Re: **Damaged Truss**
Location: Lot 94 Providence Creek (Fuquay-Varina, NC)
JDS Project No.: RDU2207505
Date of Inspection: 07/22/2021

A representative of JDS Consulting arrived on site to observe the issues reported to us by the client, which are presented, along with our recommendations, in this report.

Drawing file: SFD2204-0053 / 94 PCK - Truss Layout (4-1-22).pdf

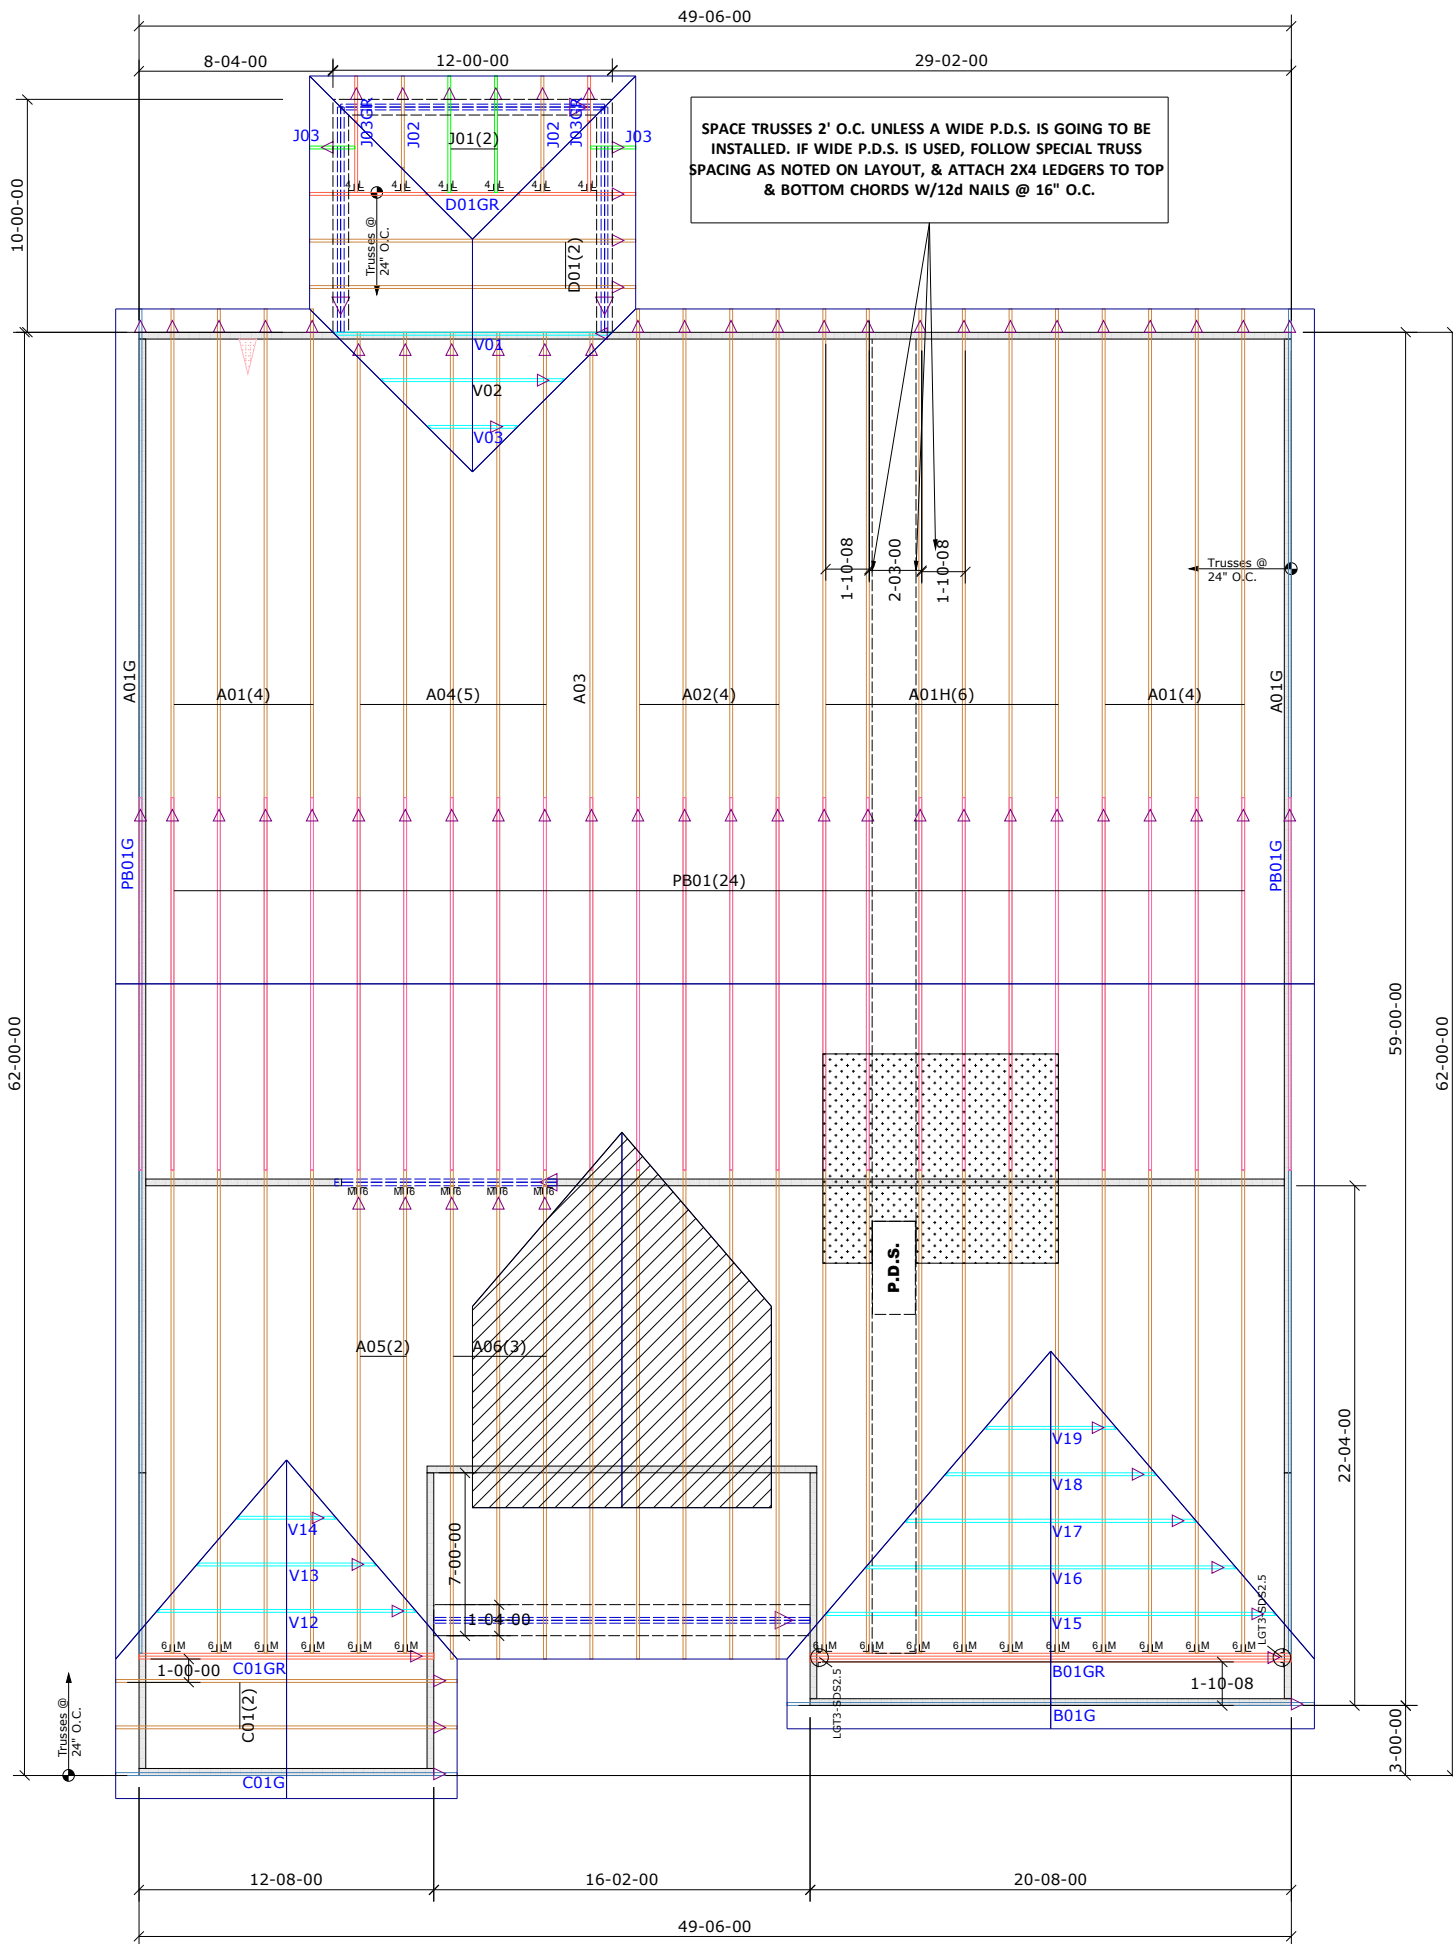
The client requested evaluation of the 4th A04 roof truss from the left gable. The A04 roof has a broken gusset on both sides of the joint 11. The contractor installed (1) 6' -0" long 2x4 scab at the left side centered at joint 11 attached with nails.

Based on our on-site evaluation and review, the contractor shall install (1) 6' -0" long 2x4 scab on the right side of the truss, centered at joint 11. Attach with construction adhesive and (2) 10d nails spaced 6" o.c. Attaching the existing scab on the left side of the truss with (2) 10d nails spaced 6" o.c., offsetting from the opposing row 3".
